**Town & Country Planning Act 1990 (as amended)
Town & country Planning (Development Management Procedure) (England) Order 2015
Application for Planning Permission for Works or Extension to a Dwelling**

Development Single storey side / rear infil extension

Location 29 Tasman Close Rustington

DRAWING TITLE
SITE LOCATION AND BLOCK PLANS

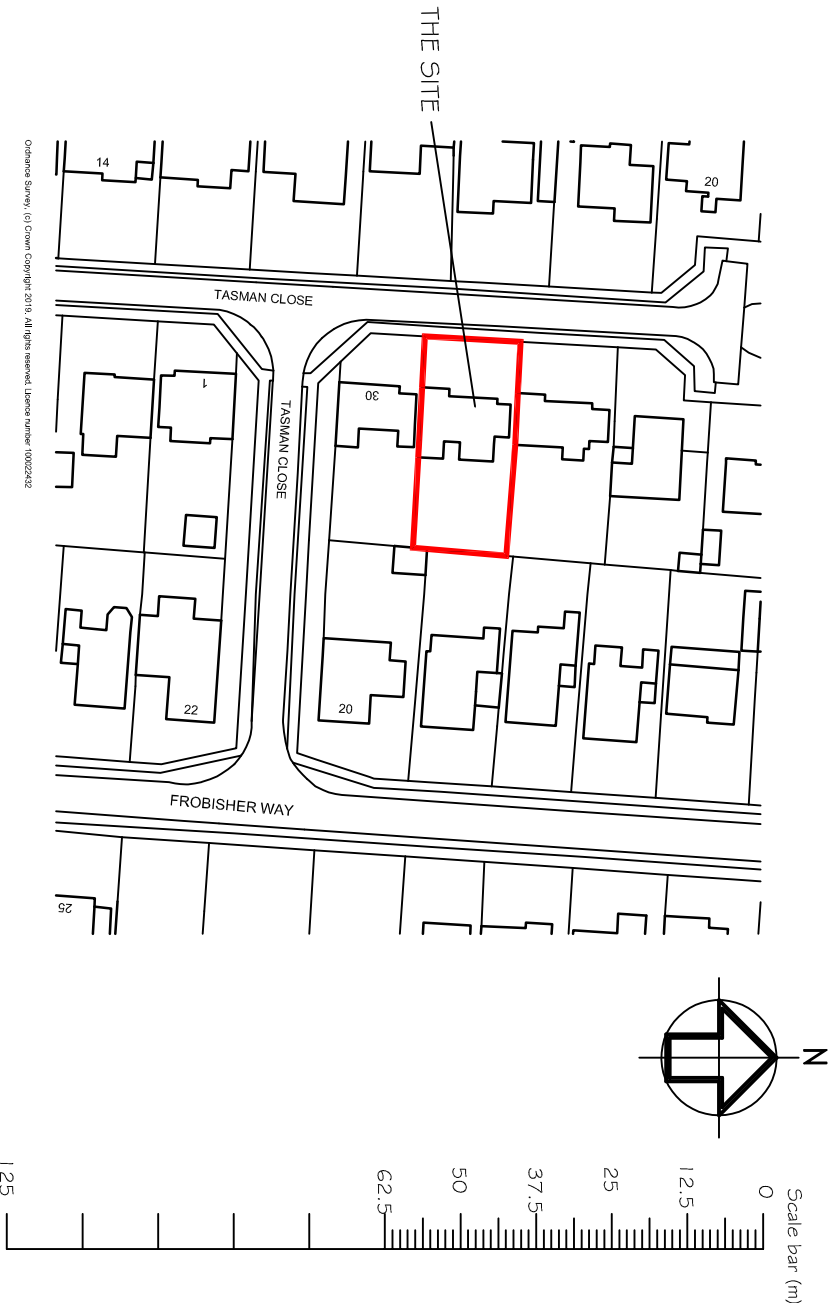
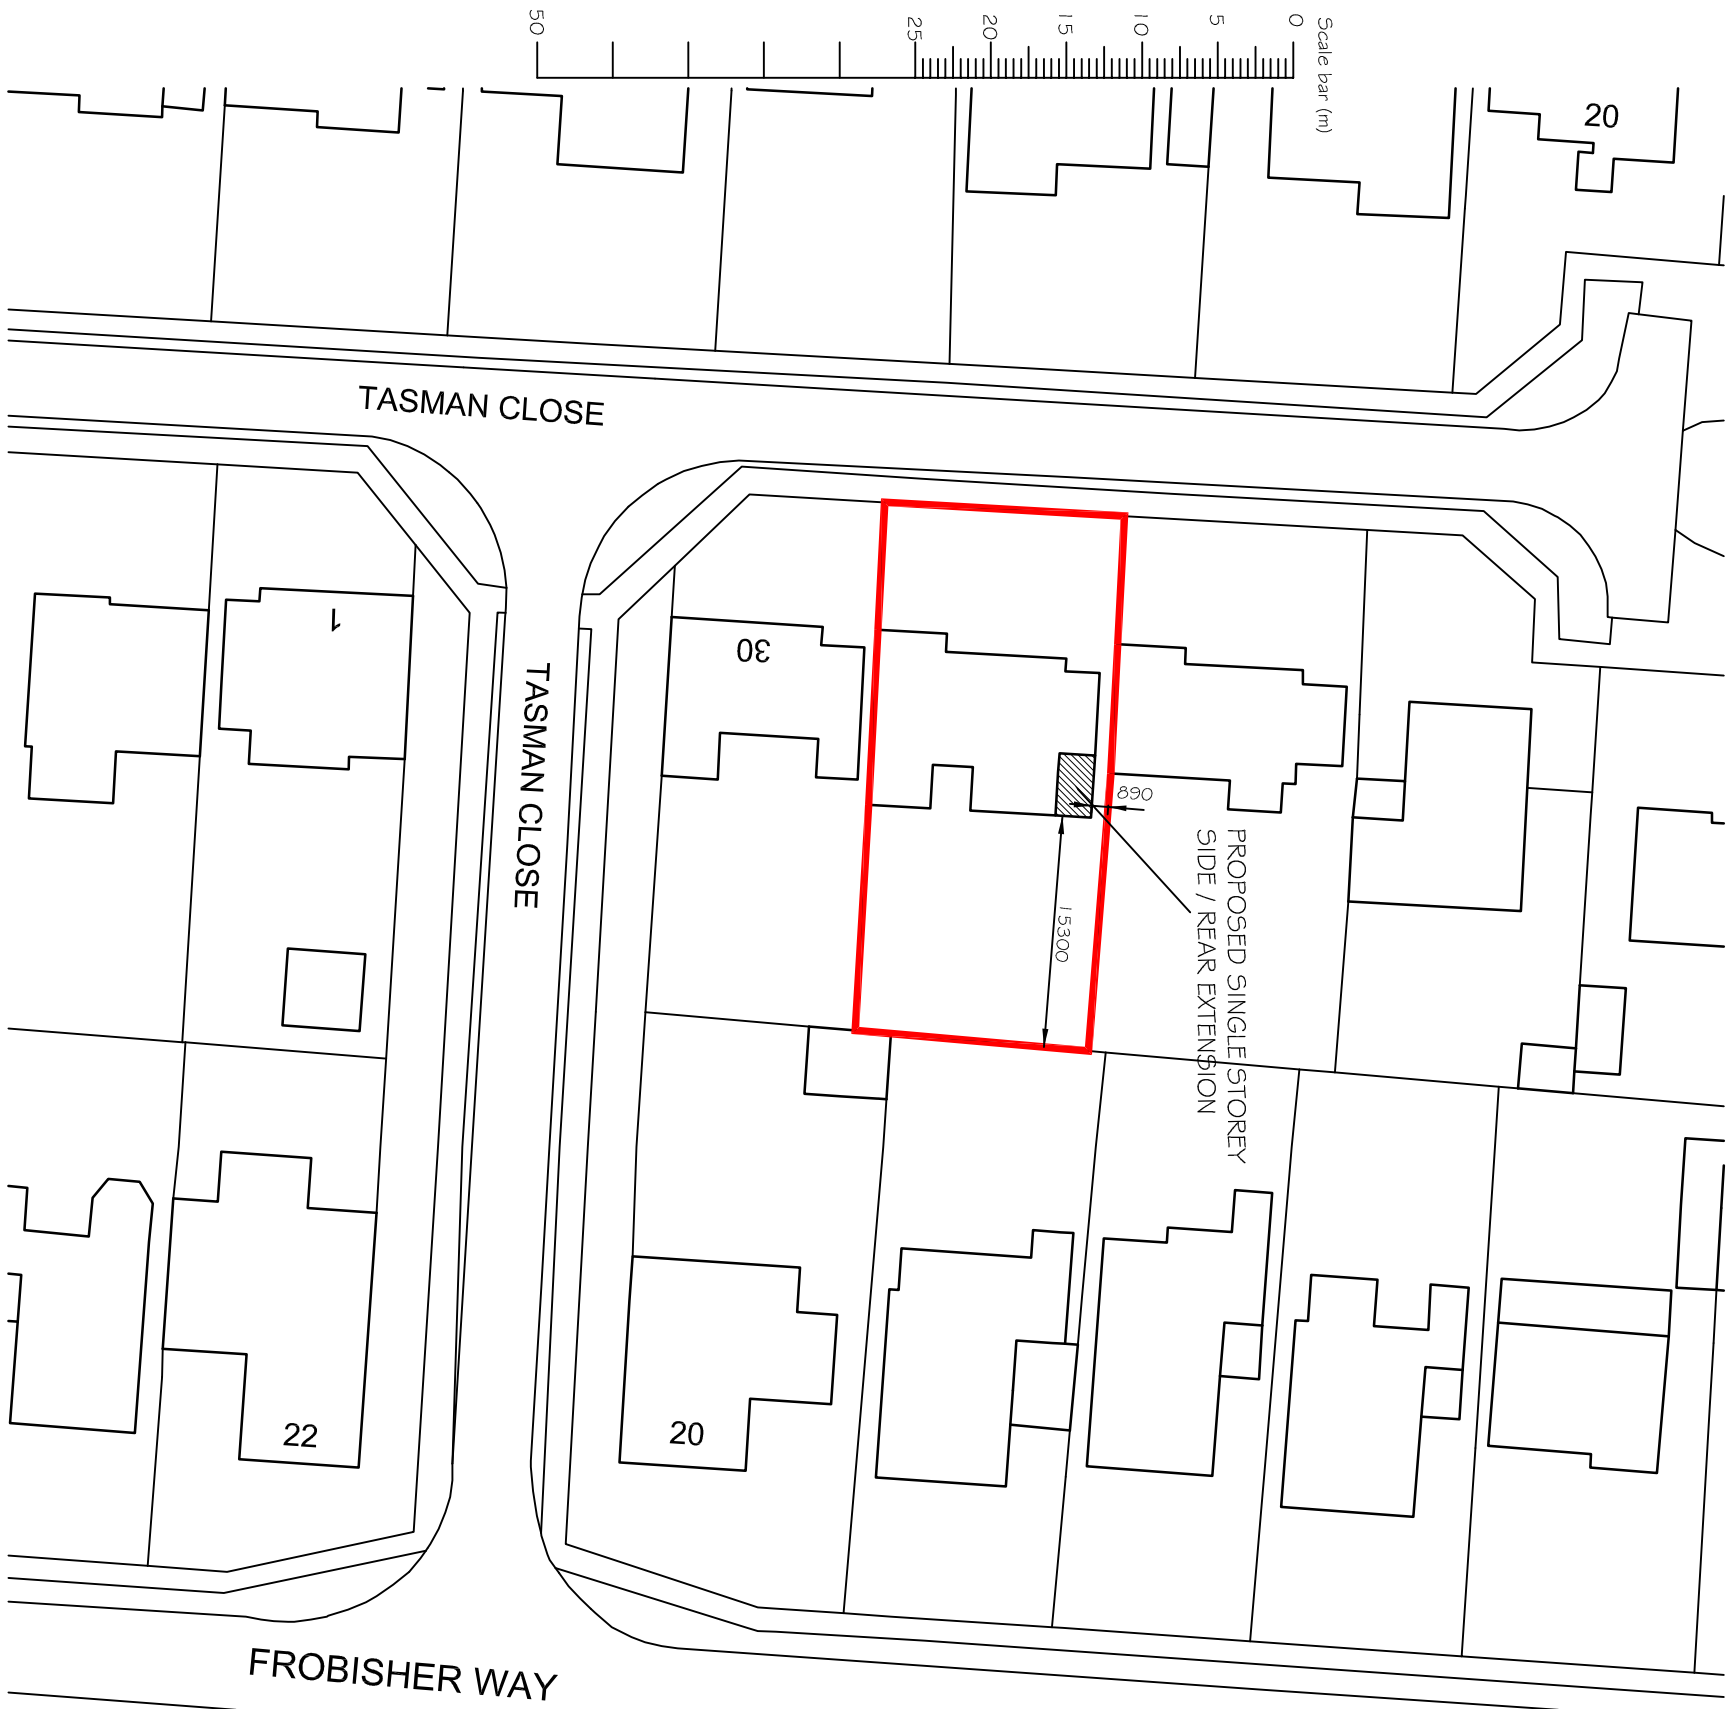
Block Plan

Please submit 1 electronic or 3 paper copies of a block/site plan which includes dimensions from the proposed extension to the site boundaries.
